Architect's Response Letter

Project: UNSER CROSSING
Date Issued: JUNE 25th, 2024
Issued by: Daniel Duran
Modulus Architects

To: COA Development Review Services

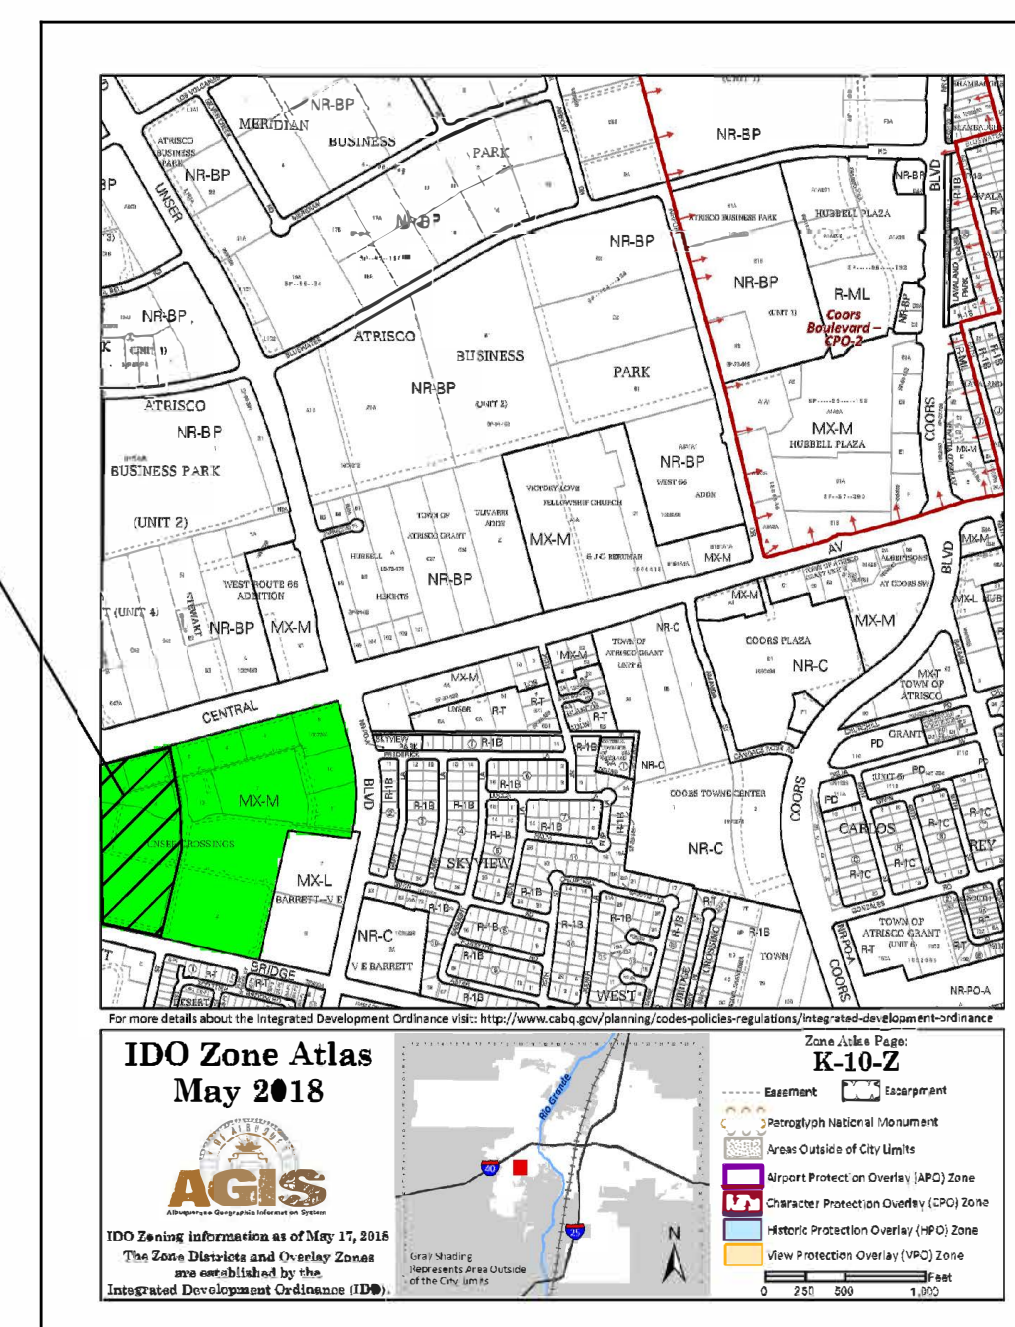
2. Show and label all existing entrances to the site off of 86th St, Central Ave, and Victory Lane. **All entrances have been labeled.**
3. Unused existing entrances are to be closed and curb and butter and sidewalk constructed. **Unused entrances are still shown on site until replat has been approved.**

6. The Long Range Bikeway System map shows a Protected Bike Lane Upgrade along the frontage of this project. Show this on the plan. **Bike lane is shown on the frontage road of Central Ave.**

9. Label Victory Lane. **Victory Lane has been labeled.**
10. Sites are required to be paved. Specify the pavement type. **Site pavement has been labeled as new asphalt**

12. Radii of 20' for the entrance off of Victory Lane are not large enough for vehicles SU-30

and larger. Specify expected largest vehicle and provide appropriate radii. **Radii off of Victory Lane has been changed to 25'-0".**

17. The sidewalk disappears at the traffic circle. **Side walk goes all around the traffic circle.**

18. Draw the mini clear sight triangles at all of the site entrances. **Clear site triangles can be found at all entrances.**

20. I couldn't find the motorcycle and bicycle parking spaces for Bldg. 2. **These have been provided for the first building to be in compliance with the whole site.**

21. Specify radii for all parking islands. **Radii for parking islands have been noted.**

22. I couldn't find the location for the bollards (Keyed Note 20). **Bollard detail and note have been provided**

23. Provide all site entrance widths. **Widths have been provided**

26. I couldn't find the locations for Keyed Notes 7 and 8. **Keyed notes have been provided.**

12 BIKE RACK
N.T.S.

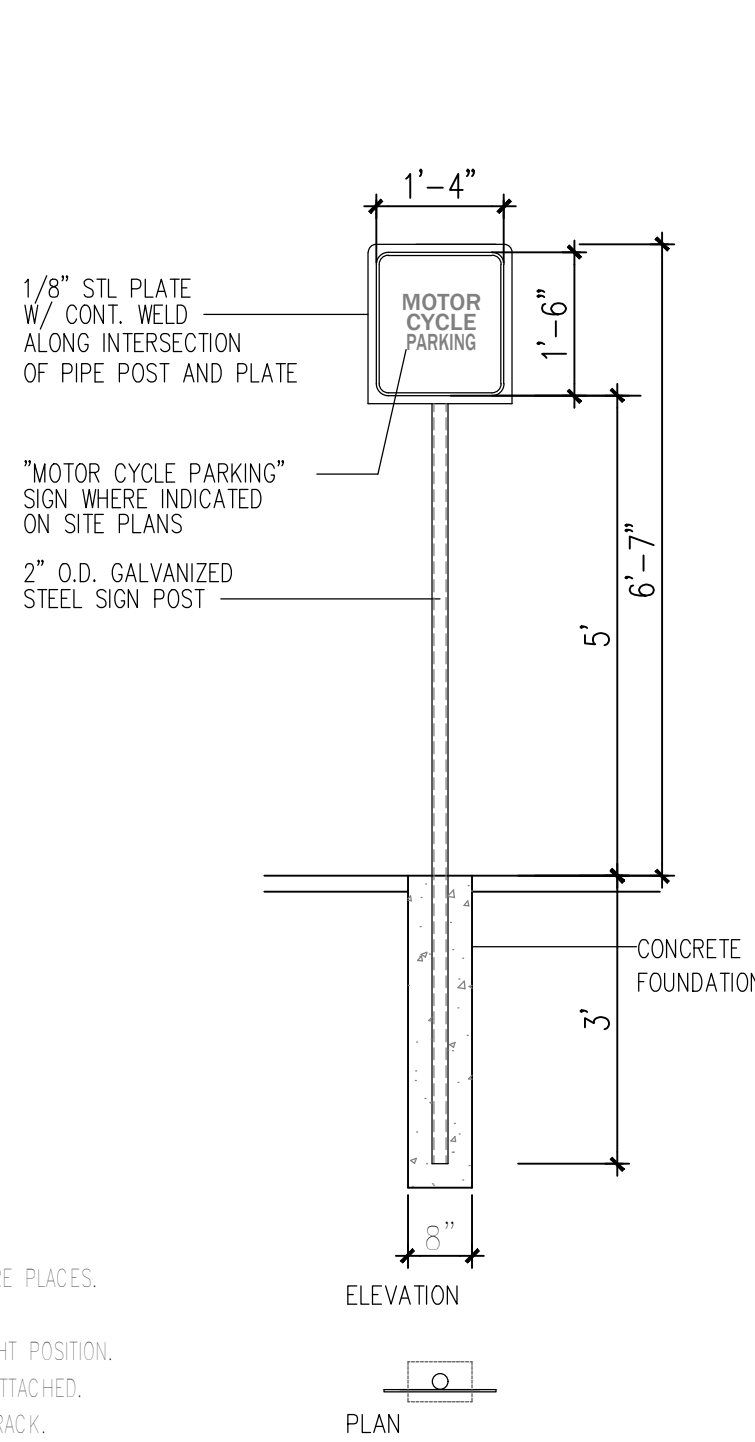
a. Provide a bike rack layout that include all racks.

d. Accessible aisles are to have blue diagonal striping, rather than the rectangles. **Details have been addressed.**

14 TAPERED RAMP DETAIL
N.T.S.

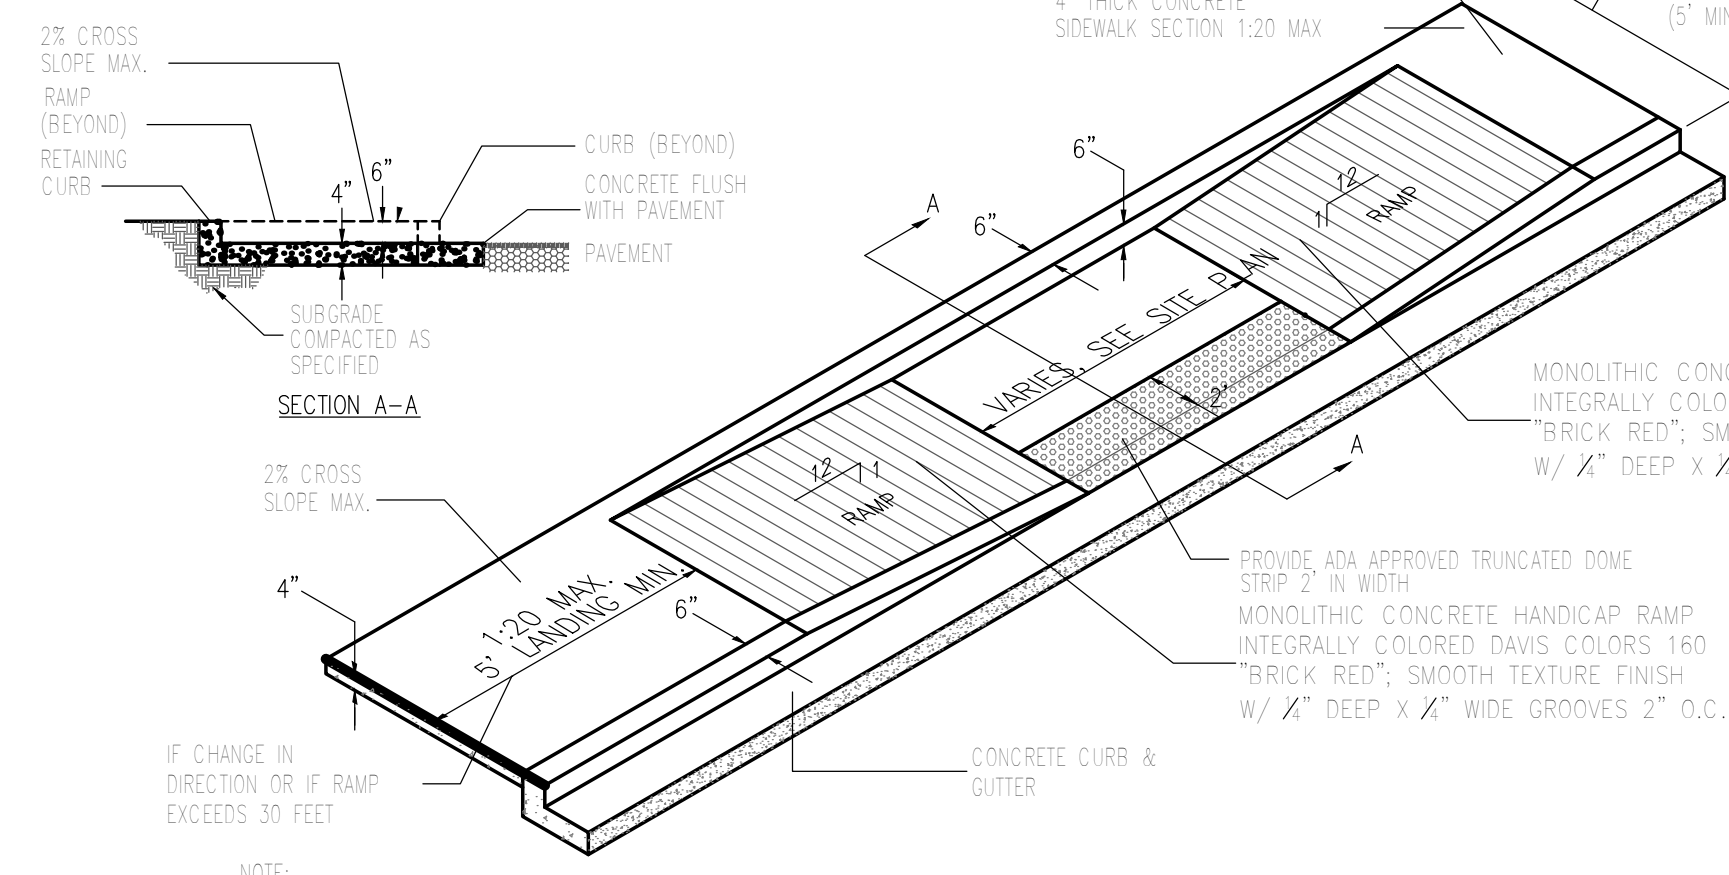
c. Tampered Ramp Detail, 14/G5 shows a 1:20 max/ The max slope for landings is 1:50 or 2.0% in all directions.
